**University of Sydney Campus Improvement Program 2014-2020 – State
Significant Development (SSD 6123) – Submission and Objection to EIS**

ENGINEERING - PROPOSED ENVELOPE PLAN

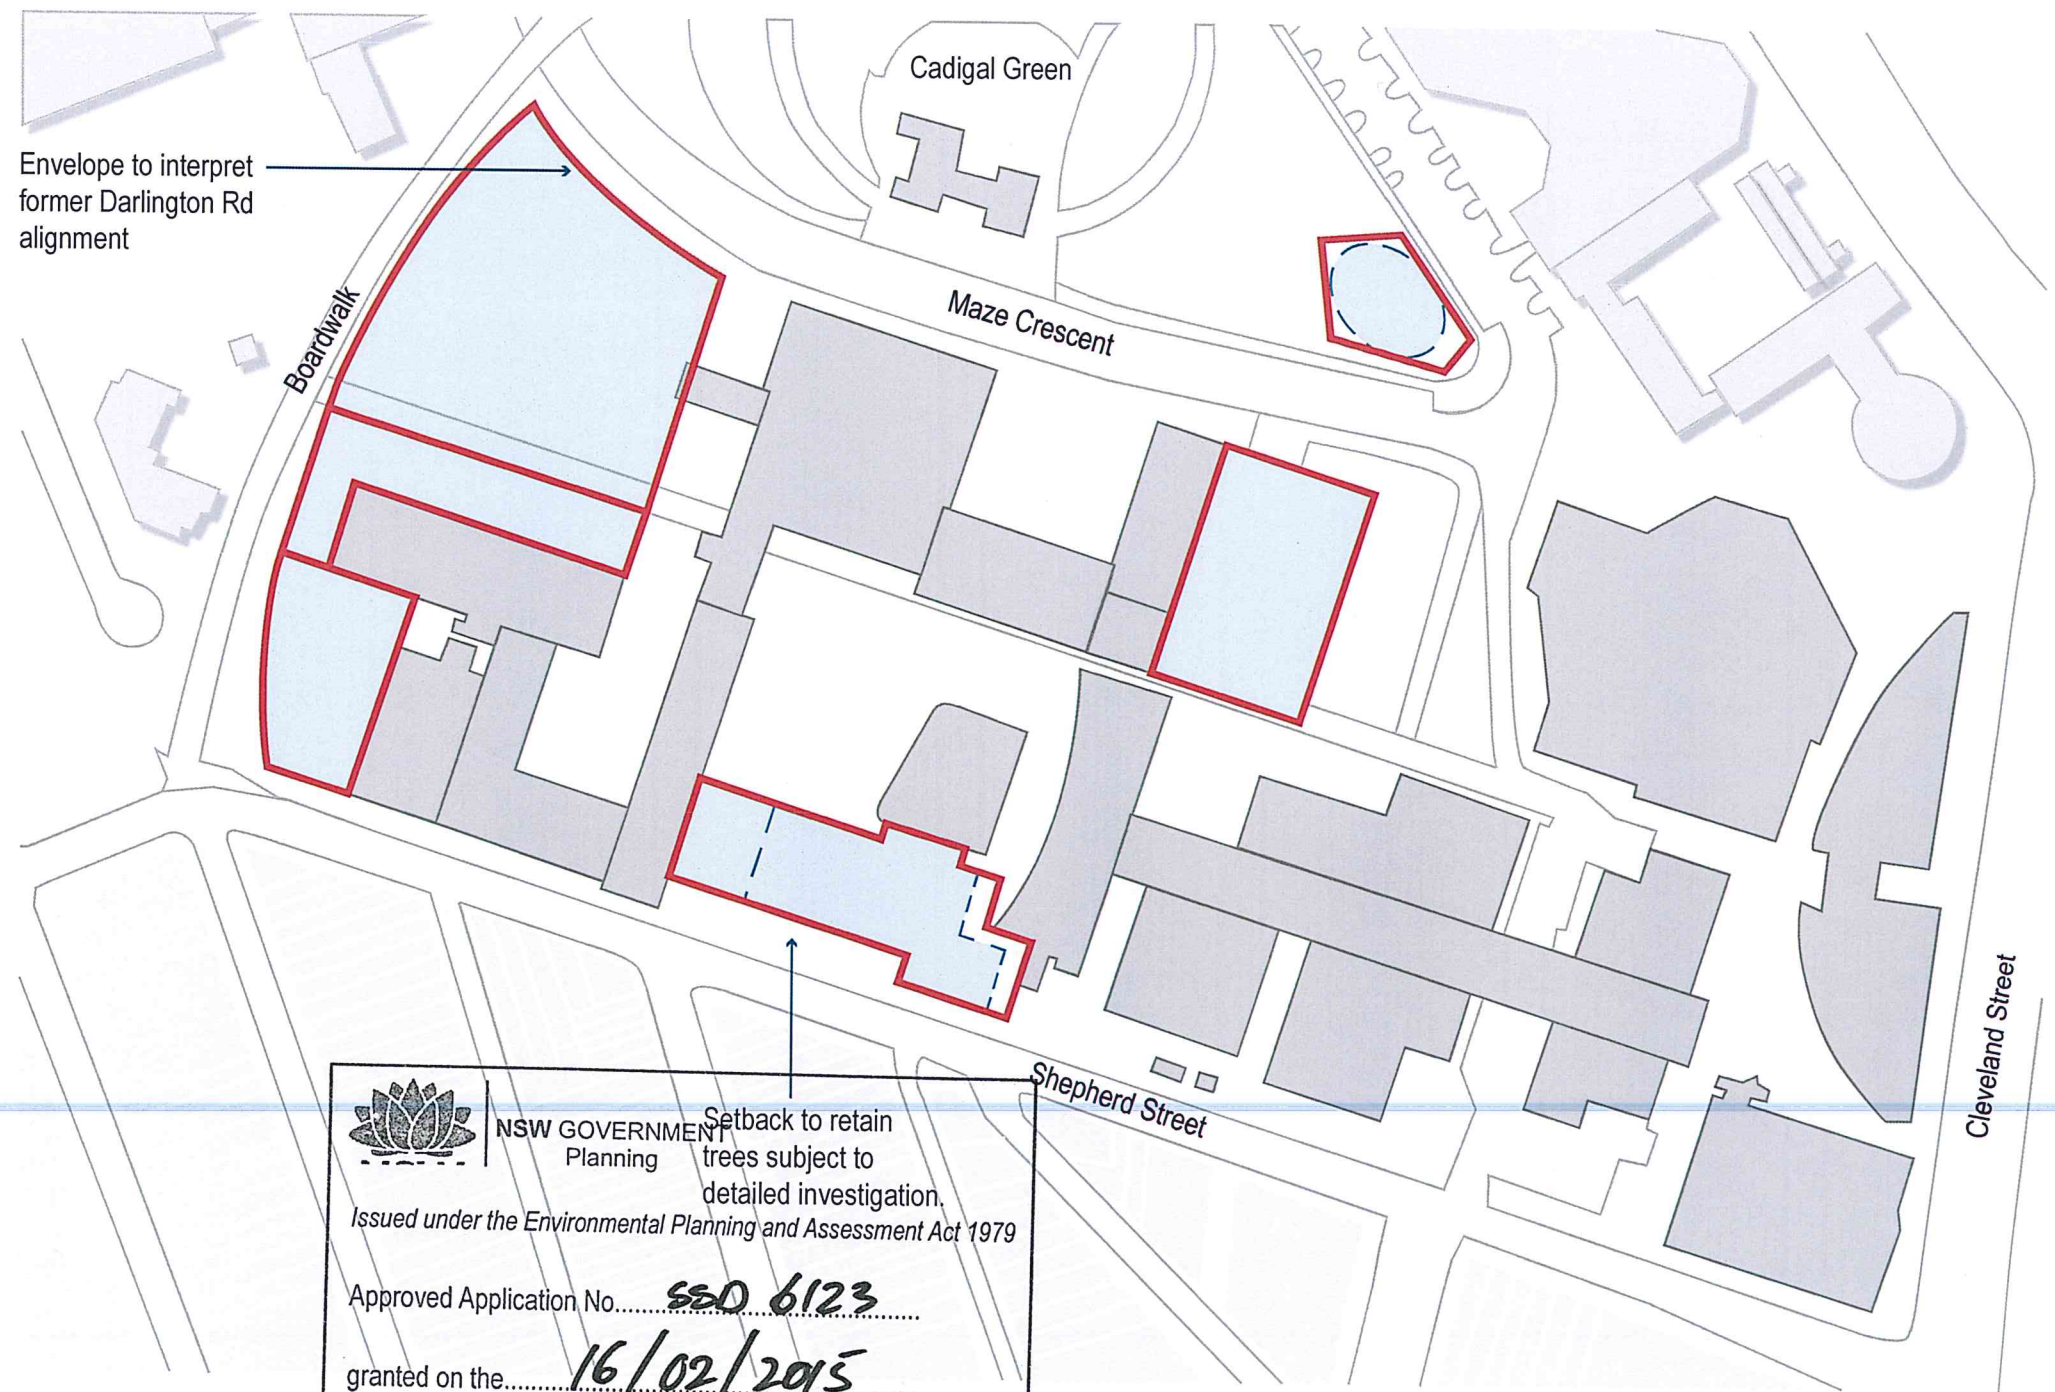
I object to the University's plan to destroy Darlington's Eucalypt Grove on Shepherd Street at the interface of the engineering campus and residential Darlington and to replace it with a 3 storey building overlooking resident's homes.

Indeed a rare, albeit small buffer zone, exists already between the large ugly engineering buildings on Shepherd Street and the much smaller nearby residential terrace houses. The University is proposing to destroy this buffer zone, a grove of 19 mature Eucalypt trees, along with the fauna that inhabit it and use it as a transitional

bridge, and construct a 3 storey building overlooking resident's yards and homes thus seriously degrading resident's amenity.

The University should implement the Council Plan by not destroying the Darlington Eucalypt Grove. If the grove were bulldozed and replaced by a 3 storey building the open vista from Shepherd St to the Engineering Lawn and the landmark PNR building beyond would be lost.
